**Washington State  
Department of Transportation**

August 16, 2010

Subject: 12 Parcel Segregation and BLA  
Segregation (SG-10-00032) Hundley  
I 90, Exit 78 vicinity - Northerly side of Interchange.

PROPOSED

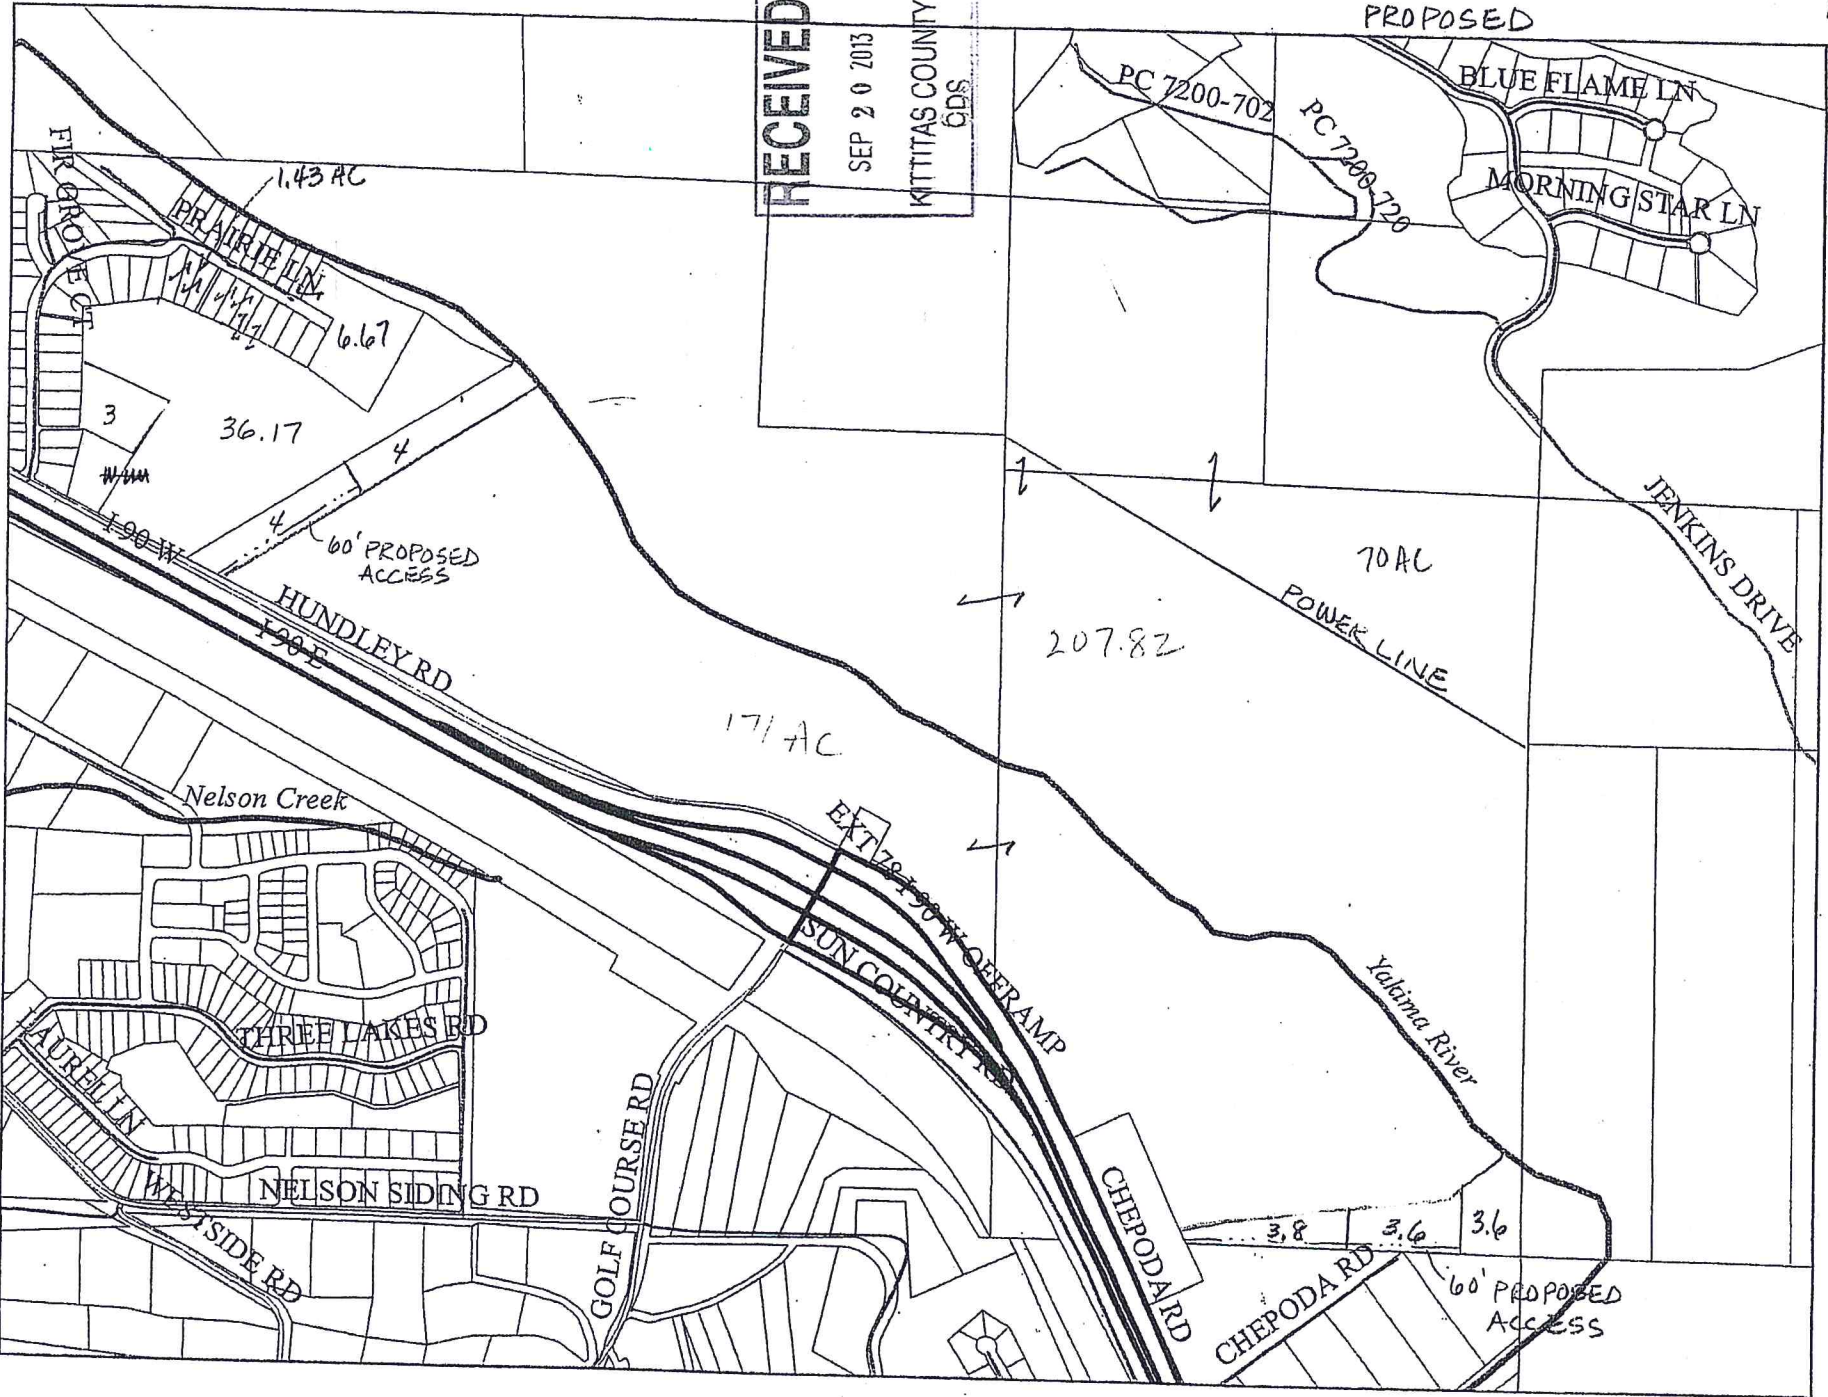
For this development, access to the property must be obtained at the county road intersection of Hundley Road, with construction of a new private road to the proponent's property.

2. The 60' proposed access shown at the end of identified "Chepoda Road" must terminate at the 3.8 acre parcel, and not extend to the rectangular shaped parcel to the west that is owned by the WSDOT (see attachment). No access across this parcel owned by the WSDOT, or the haul road, will be allowed.
